**Environment  
Agency Written  
Representation on  
Sizewell C  
Development  
Consent Order**

Our Reference: AE/2021/126206/01

2 June 2021

DRAWING NO: SZC-SZ0100-XX-000-DRW-100205	REVISION: 02
DATE: JULY 2021	DRAWN: CGK
	SCALE: AS SHOWN @ A1

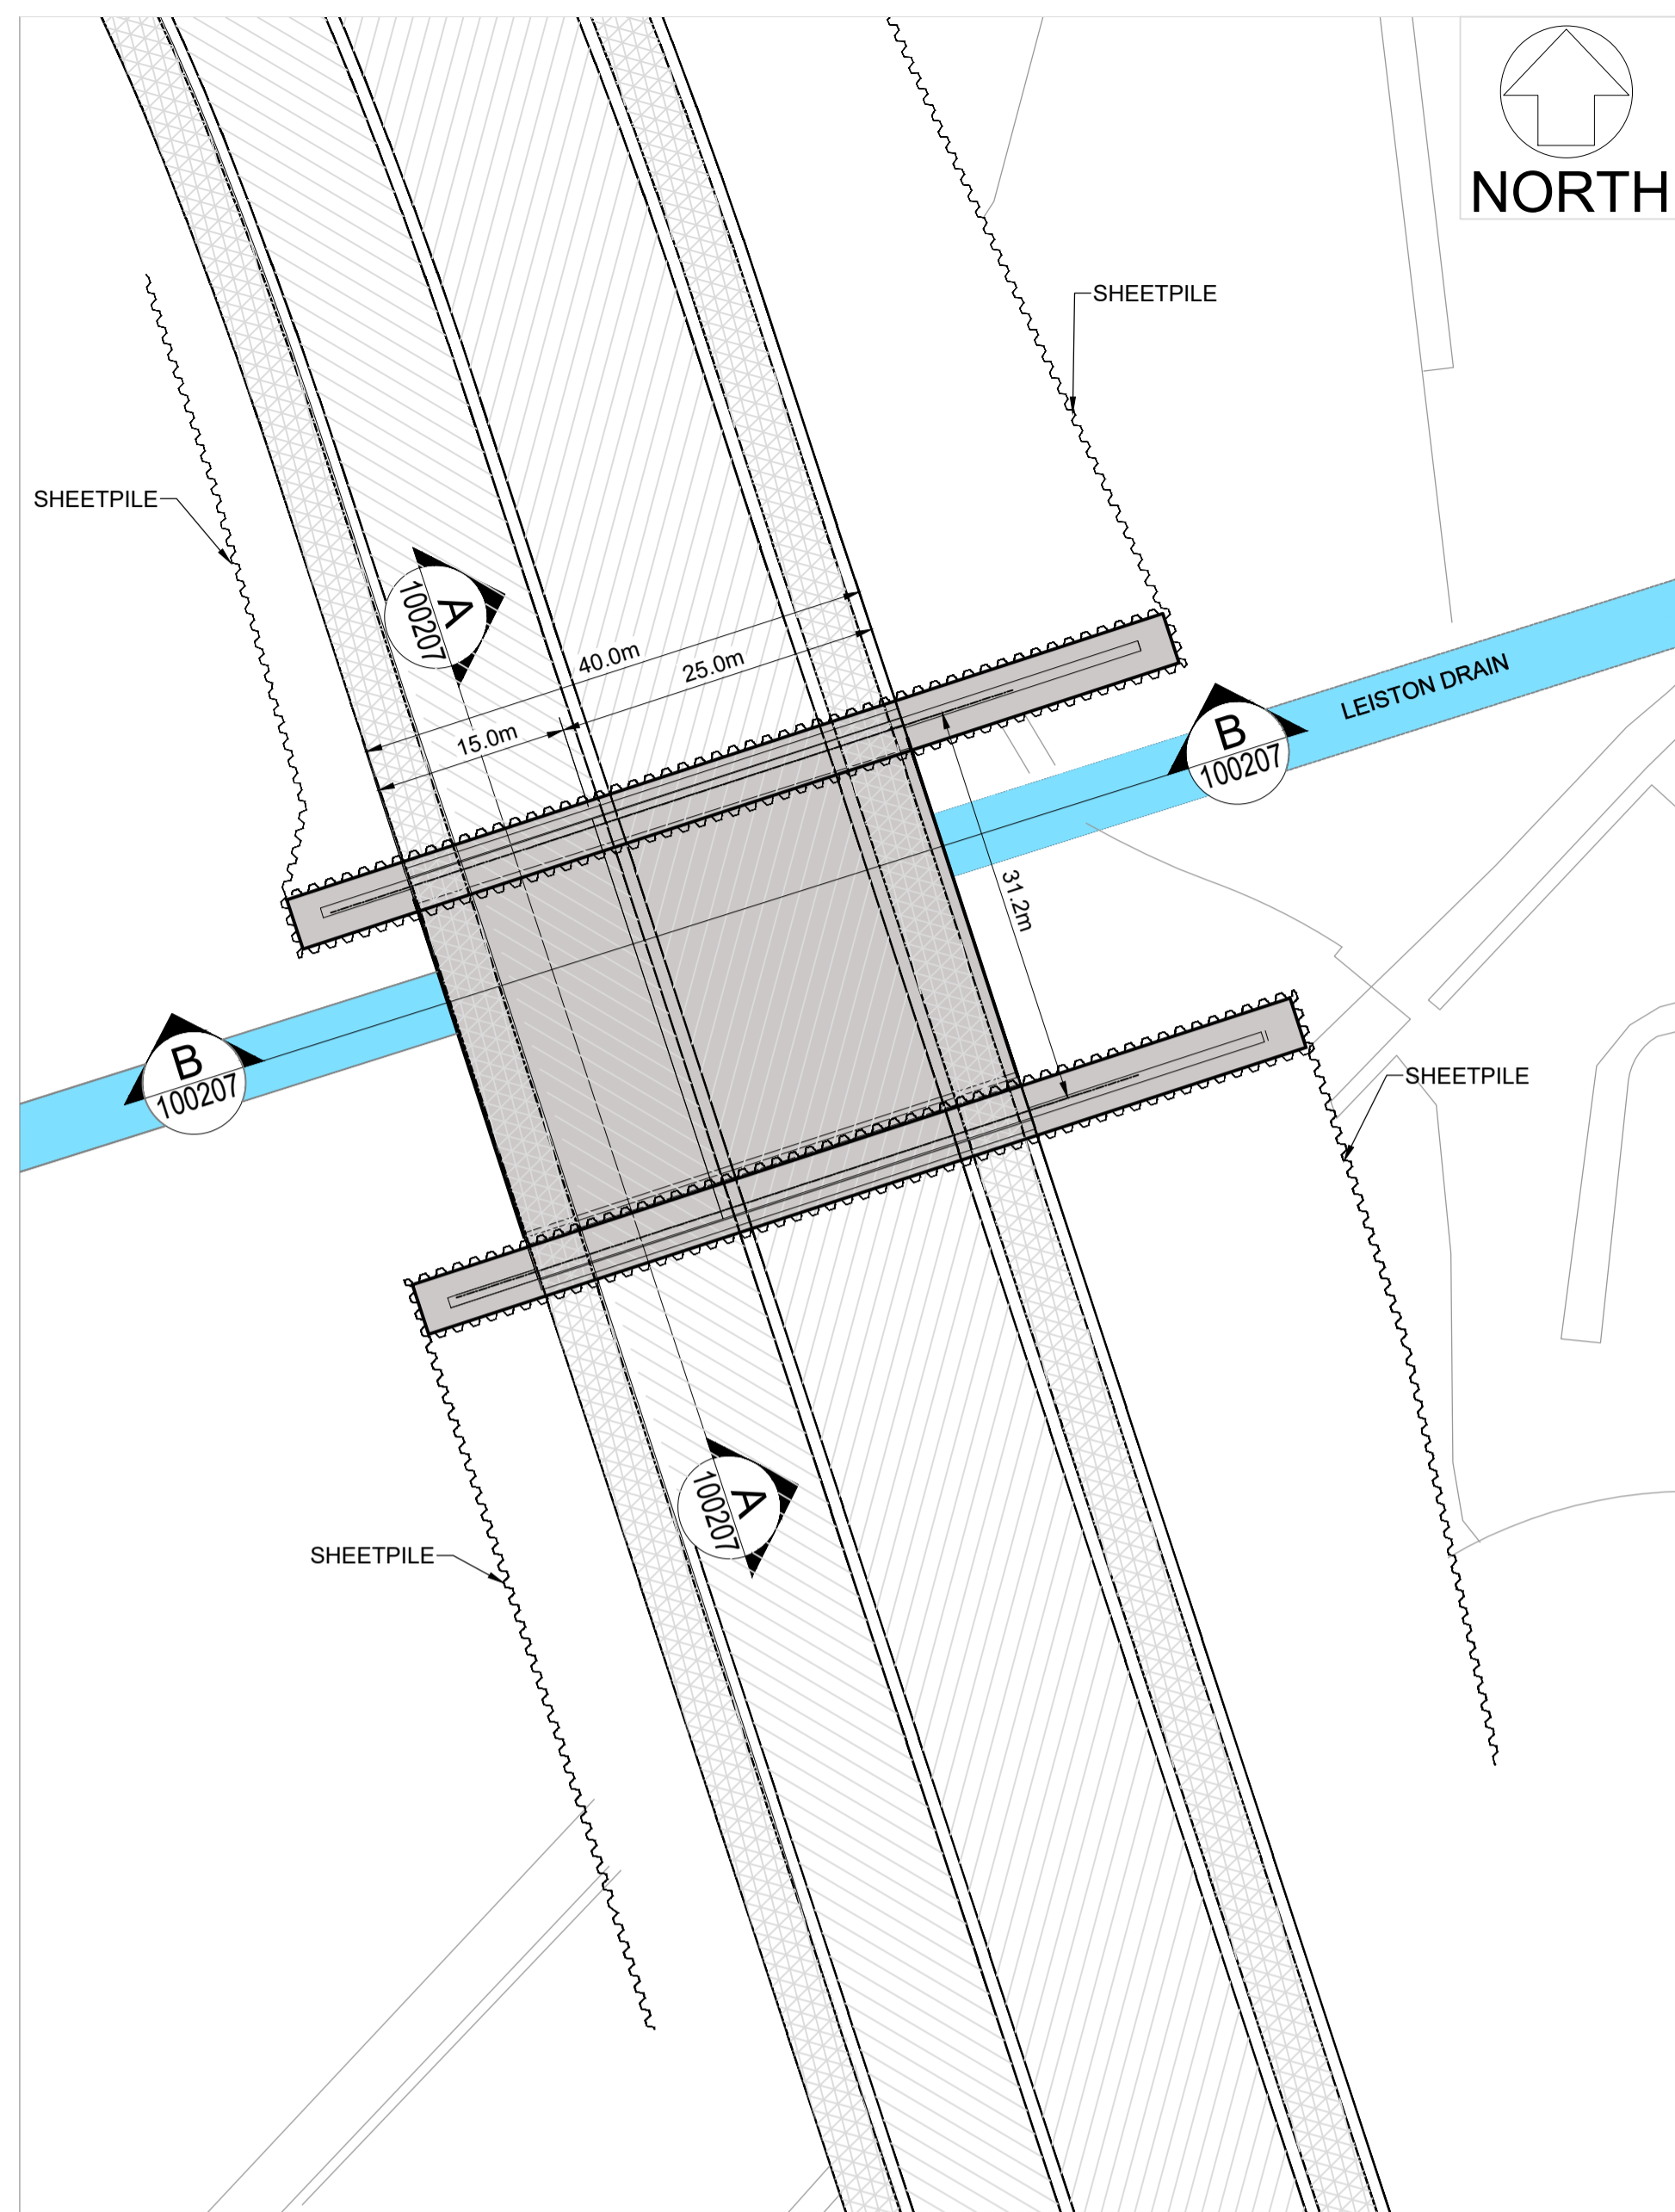
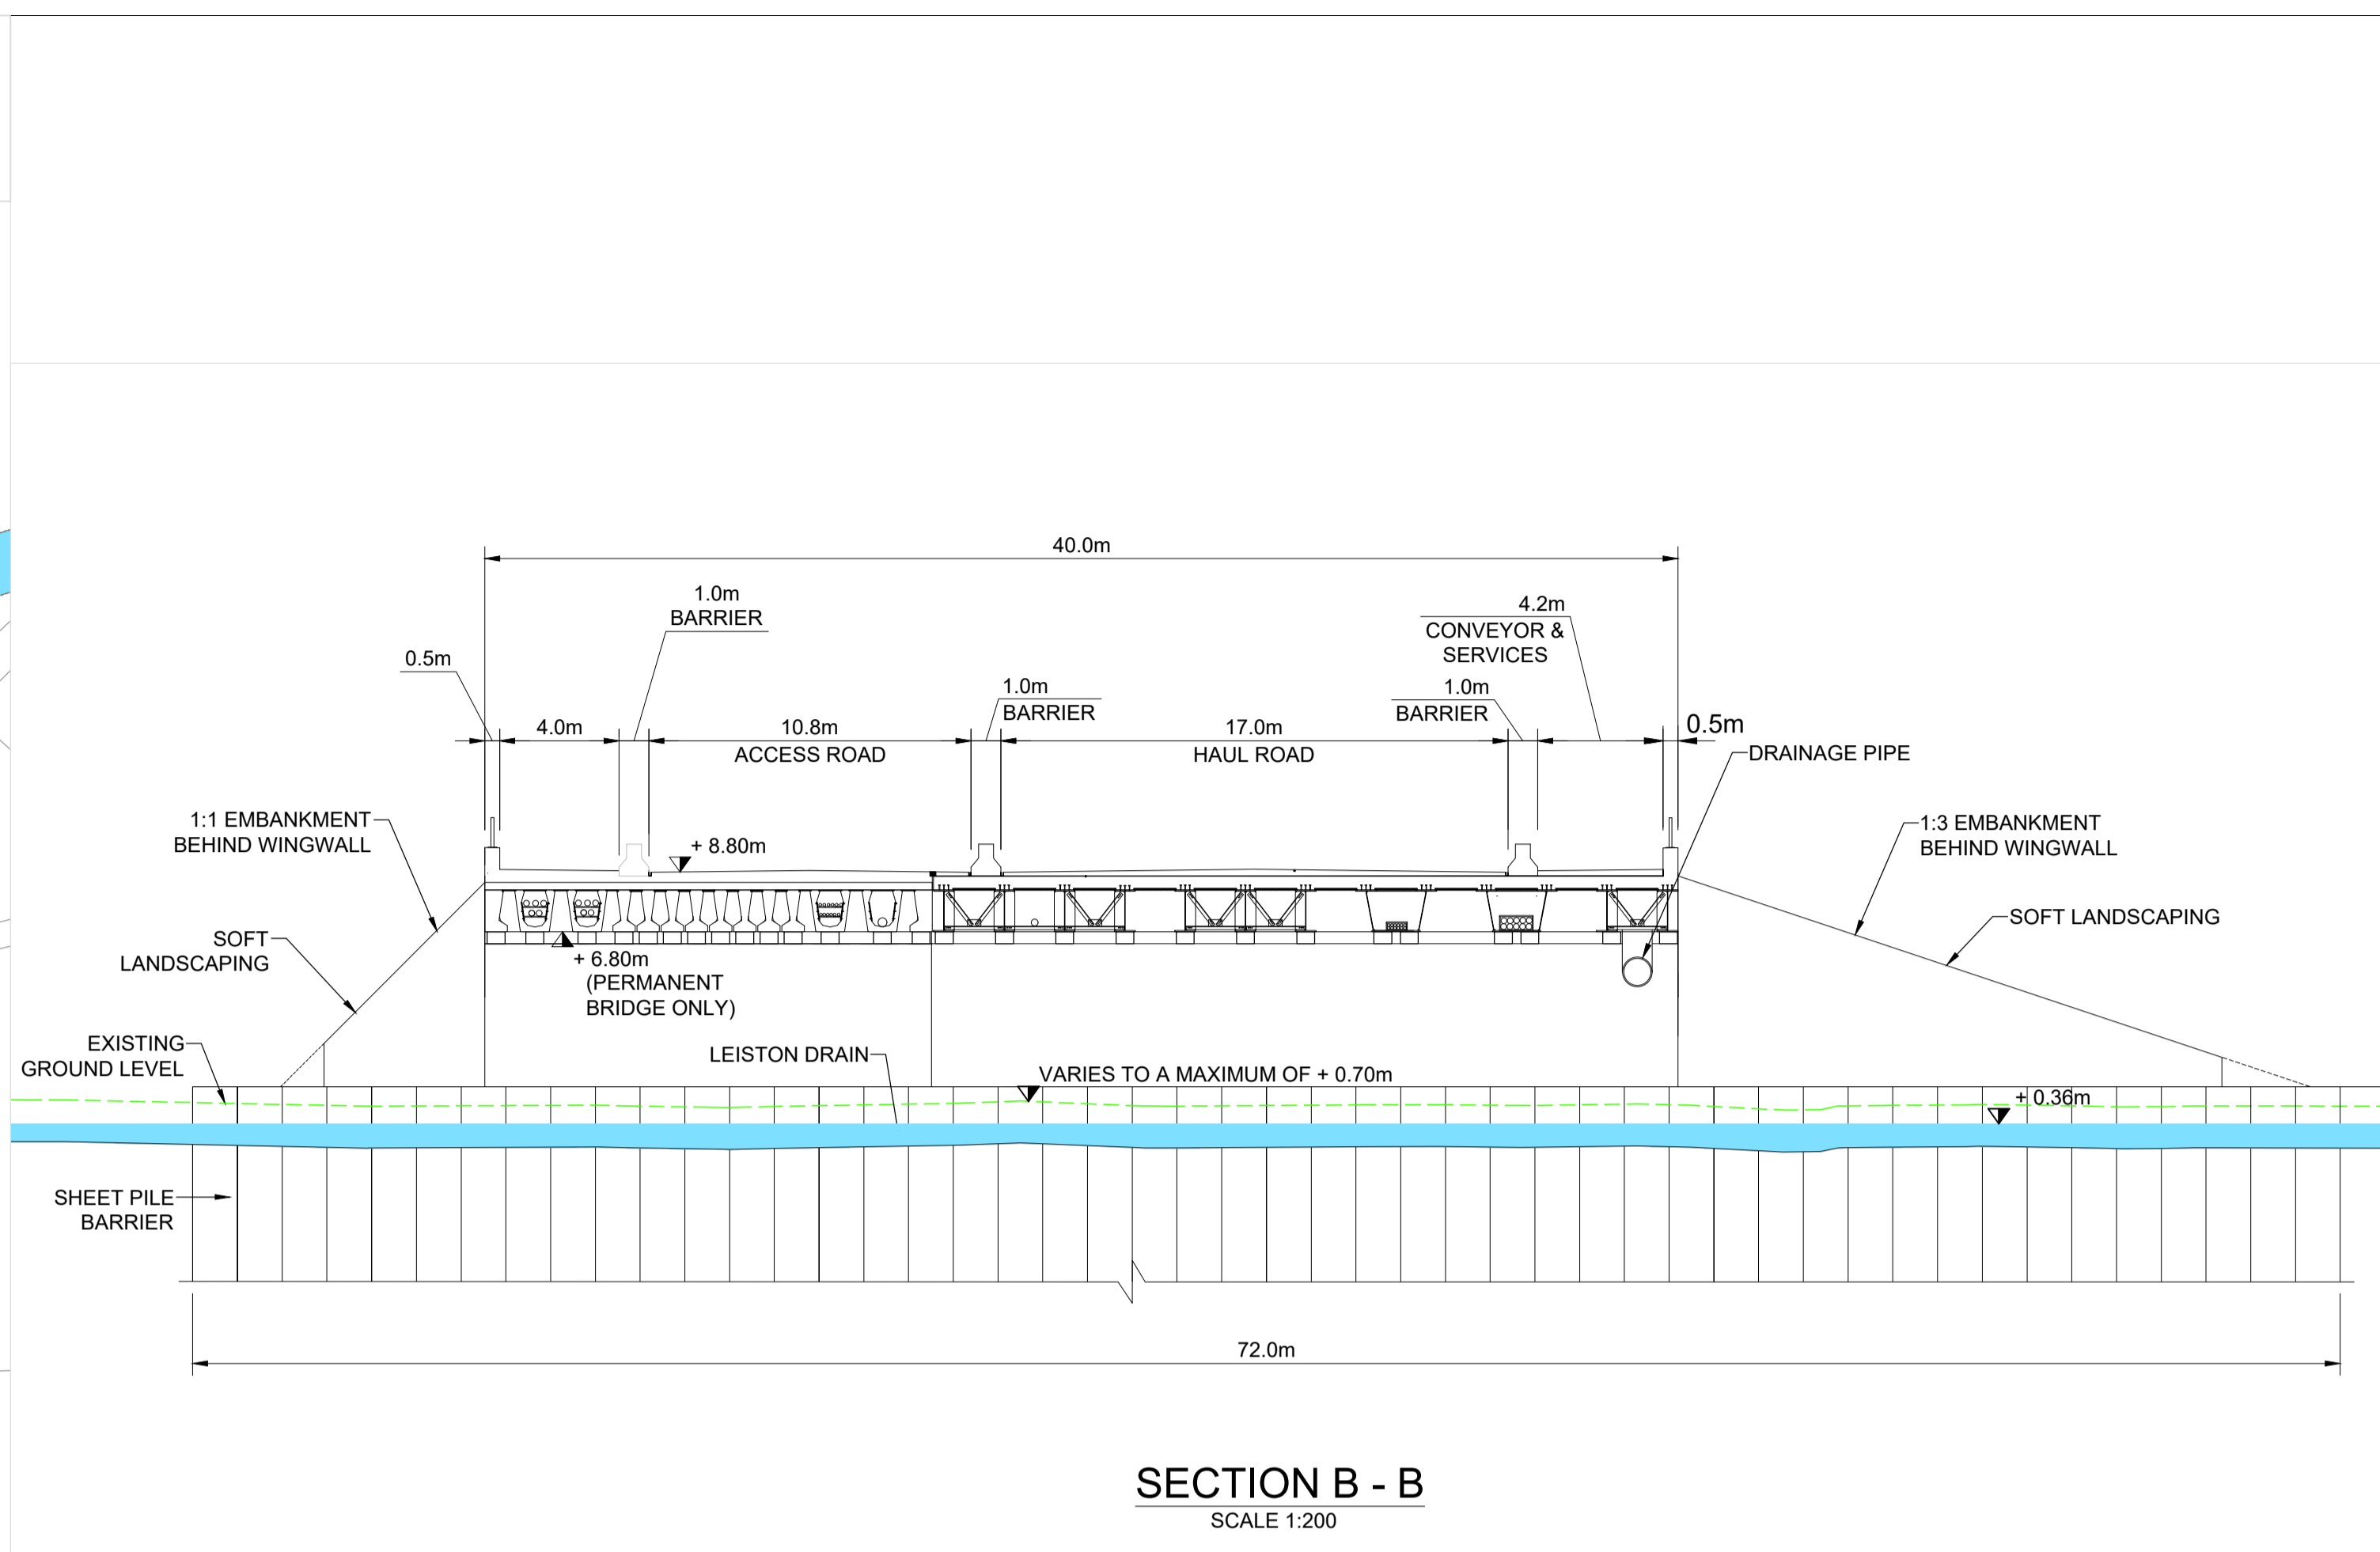
- 7.0 The change to the design of the SSSI crossing is an improvement from the previous culvert design because it will better facilitate the passage of mammals including otters and water voles. However, the proposed design will be impassable by certain invertebrates due to the height of the crossing and the large shaded area under the crossing.

- 7.1 The proposed design of the SSSI crossing would prevent the upstream and downstream migration of numerous invertebrates either side of this significant structure approximately halfway along the river, and its associated SSSI designated habitat. This will lead to fragmentation of sensitive habitats and the isolation of species populations, some of which are not resilient to this kind of impact and will be significantly less resilient to future impacts. Choosing this approach to site access may well lead to a detrimental population decline in this area for several important species. We understand that NNBGenCo (SzC) are carrying out a design review to consider if the design of the structure could be optimised to further reduce impacts. At Deadline 4 we anticipate confirmation of a design 15m wide, with an increased soffit height, which would be an improvement upon the current design.

- 7.5 **Fish:** The changes to the SSSI crossing will likely improve fish passage along the Leiston Beck but a deeply shaded area under the crossing will remain; a threshold of light intensity will determine what species are likely to pass under the crossing. This could lead to large scale fish mortality when fish are prevented from moving along a watercourse during events when water quality is reduced to a critical level, such as algal blooms, or pollution events. NNBGenCo (SzC) Ltd has indicated that there will be further optimisation made to the design of the SSSI crossing, which will be necessary to resolve these impacts.
